Wootton Parish Council (Northern Site) Additional Comments in Regard to Local Impact During the Examination Phase 22 July 2025

**Operational Development Plan
Northern Site Area 1 of 2**

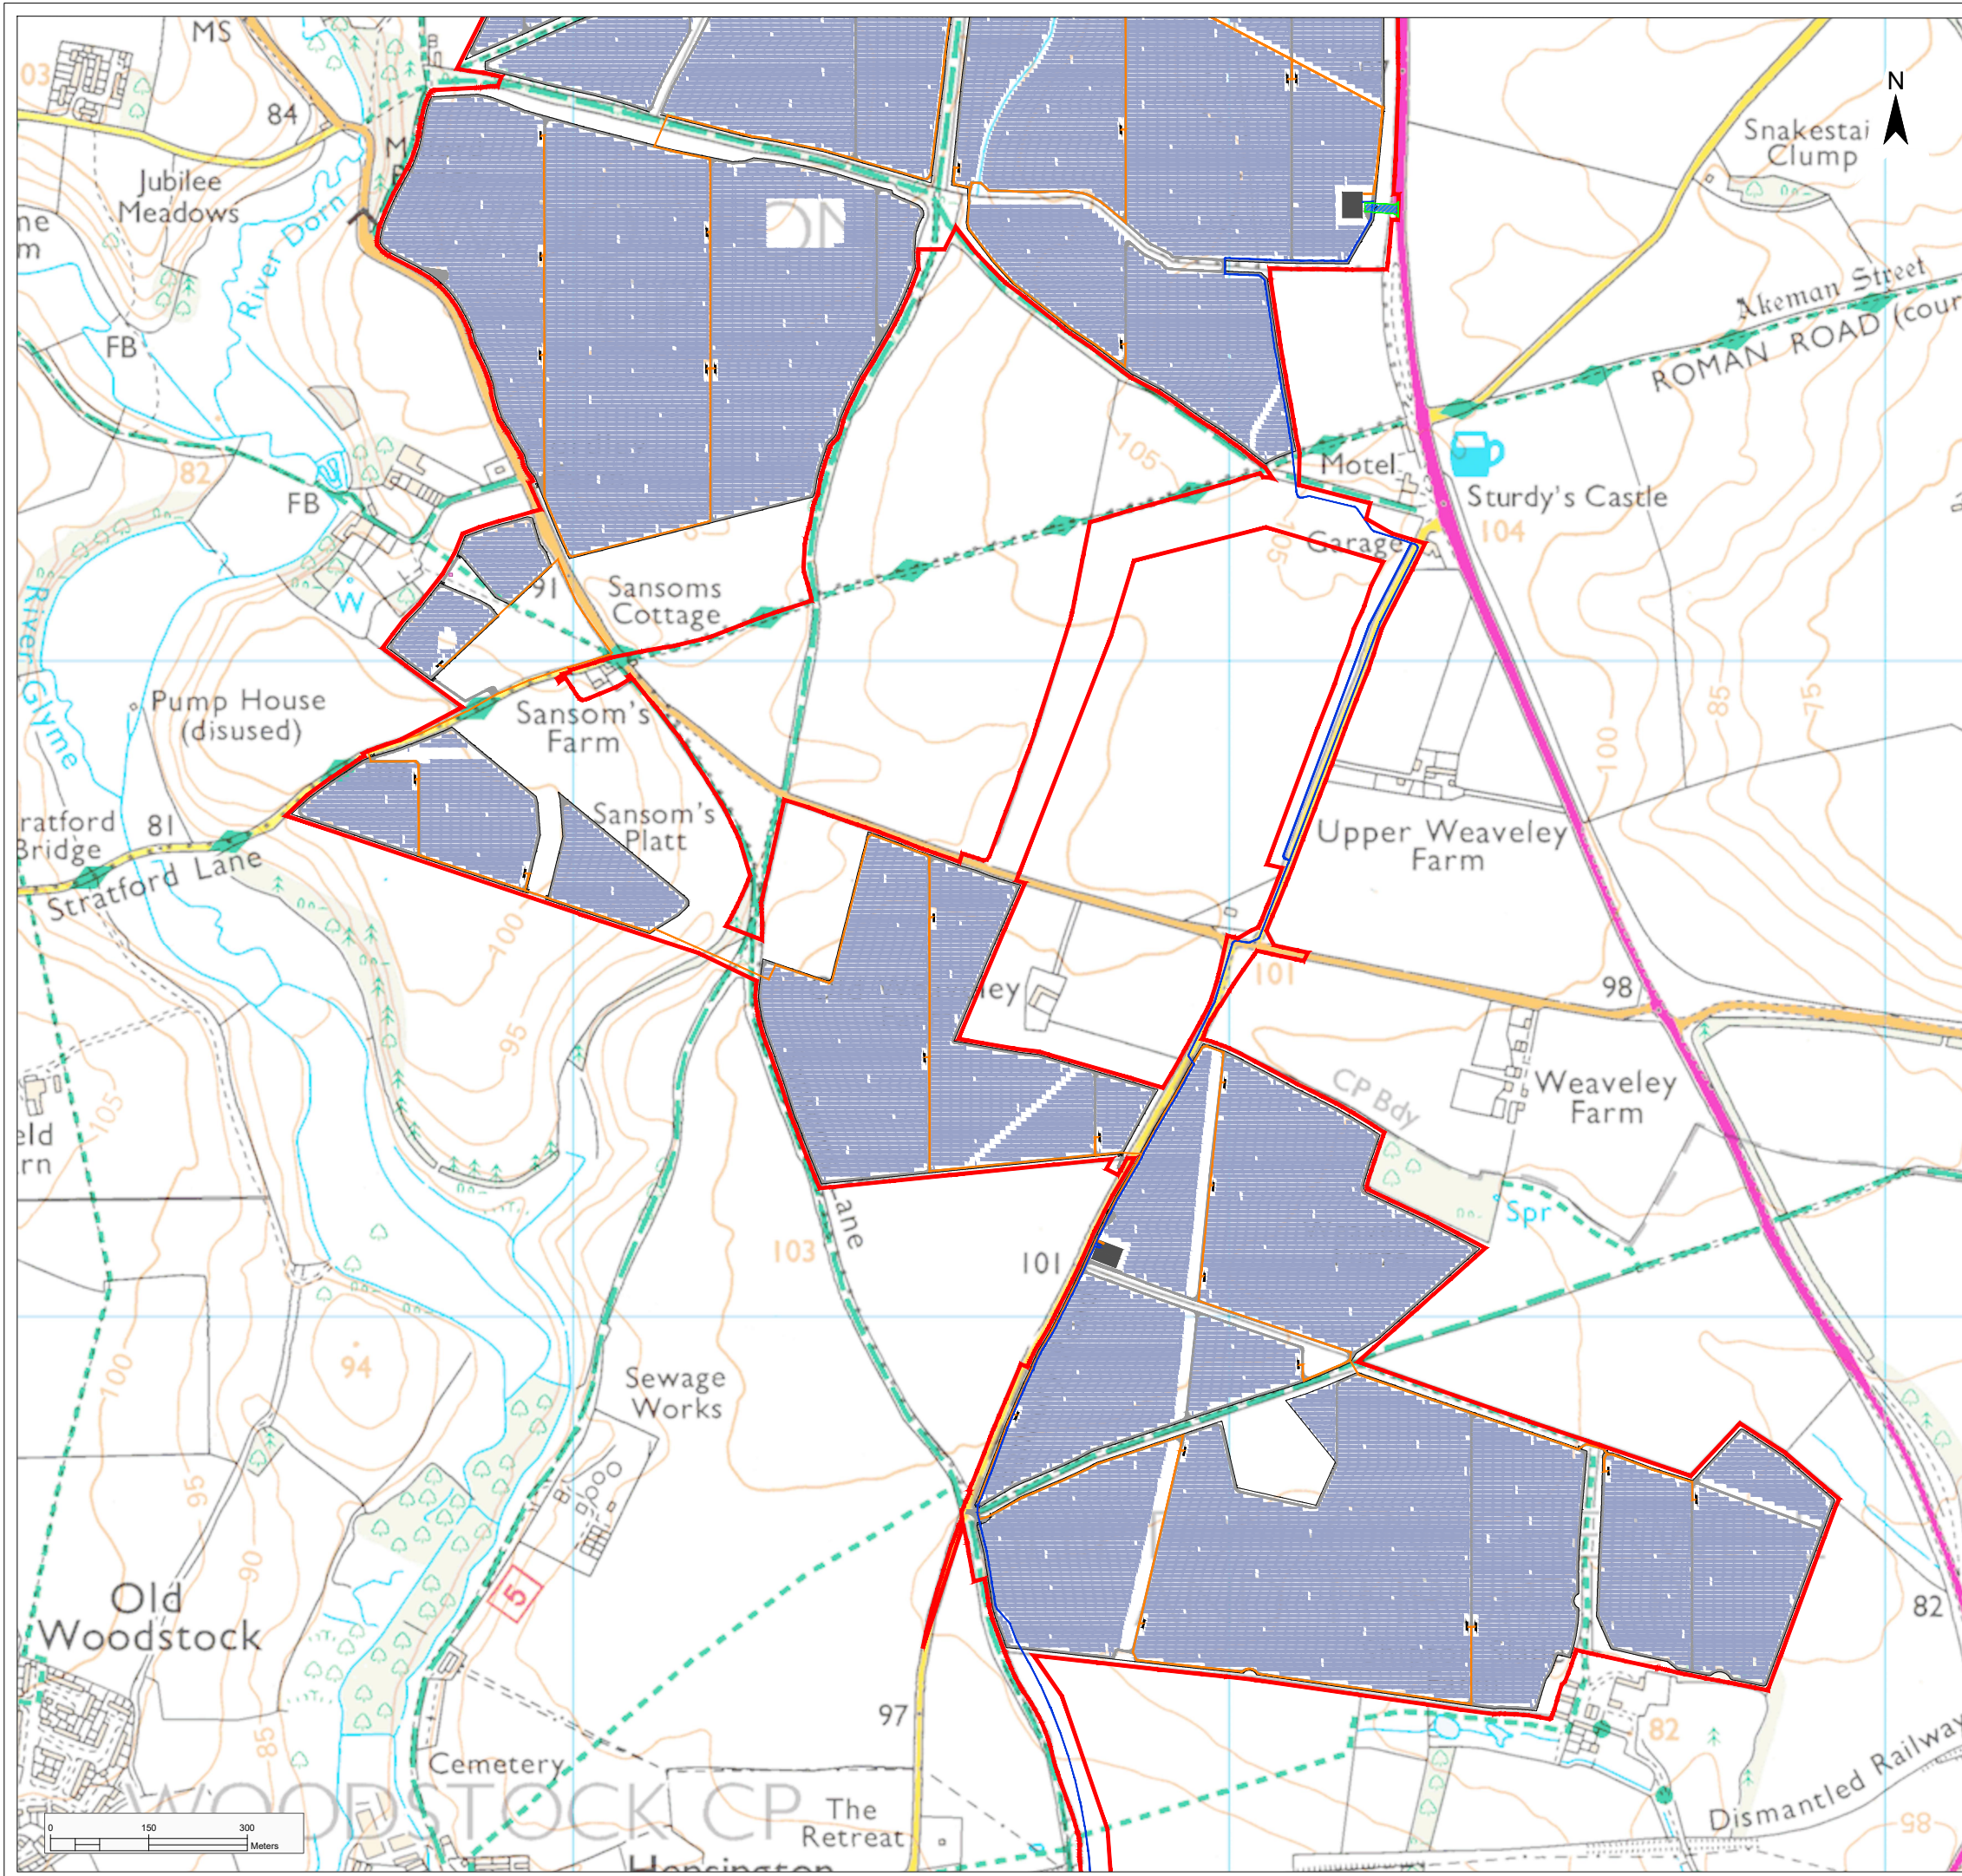
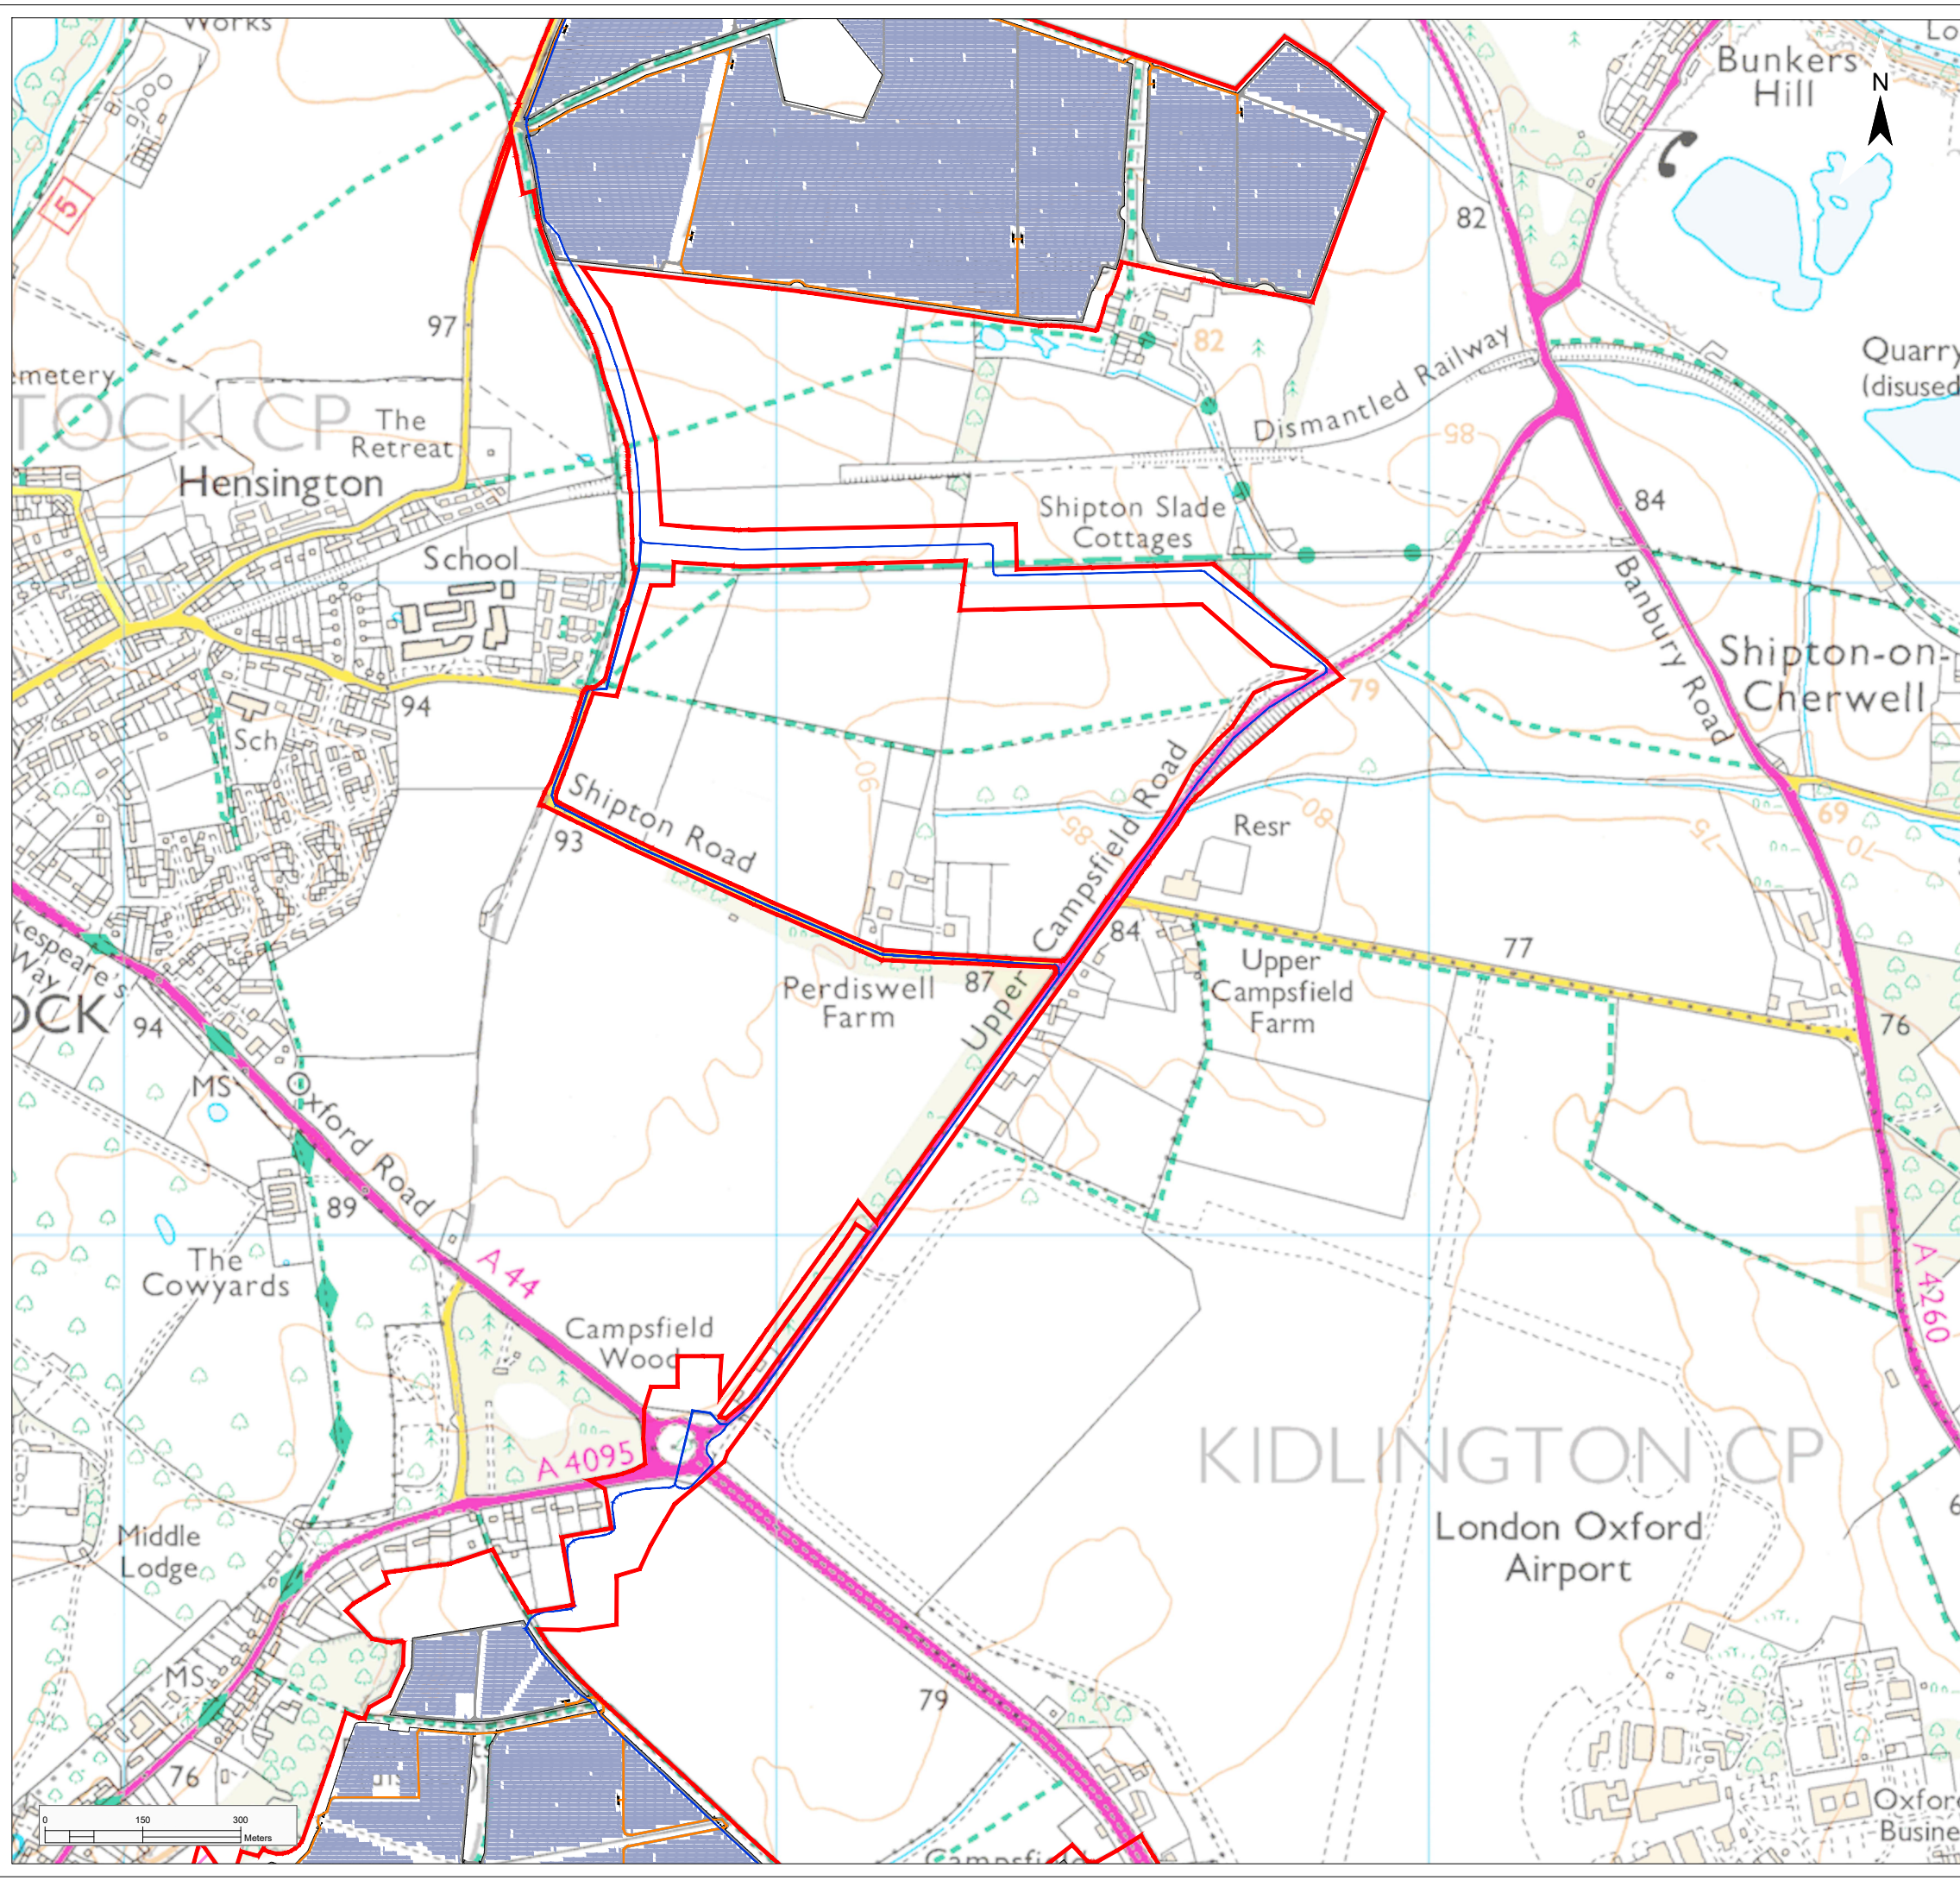
We are concerned that cabling is proposed to be laid along Dornford Green and request more detailed information about how this will be installed and where and what the maintenance plans shall be.

We would like more information in regard to a substation that appears to be behind a hedge on the east corner of the Dornford Field. What will be its size, purpose, operational activity and noise levels? What mitigation measures might there be?

At the Northern site area, both Dornford Lane and the Oxford Way are located on the site with the listed buildings of **Lower Dornford Farm**, **Hordley House** and there is also the rural **Dornford Cottage**. WPC remains concerned that siting arrays on this site along with the proposed mitigation methods such as metal fencing or hedges around Public Rights of Way that will fundamentally change the way the landscape and views are appreciated. This open green space bordering ancient woodlands with numerous perching owls, bats and biodiverse habitat and other species such as hares existing in open land would become an enclosed sea of glint and glare solar panels. The name Dornford illustrates links to the nearby rivers that enable a vibrant ecosystem to thrive and link the site to the nearby water meadows and wildfowl.

Residential housing is located within and on the border of the Northern site. In particular, **Dornford Cottage** will be surrounded by arrays despite a small buffer. The fields will have no screening contradicting the Glint & Glare: assessment of "no impact" due to "existing/proposed vegetation" with no mitigation recommended. The industrialisation of a resident's environment to this extent, must have a serious impact on life, wellbeing, health and financial security. **Hordley House** will also be negatively impacted after centuries of pastoral serenity as a medieval house.
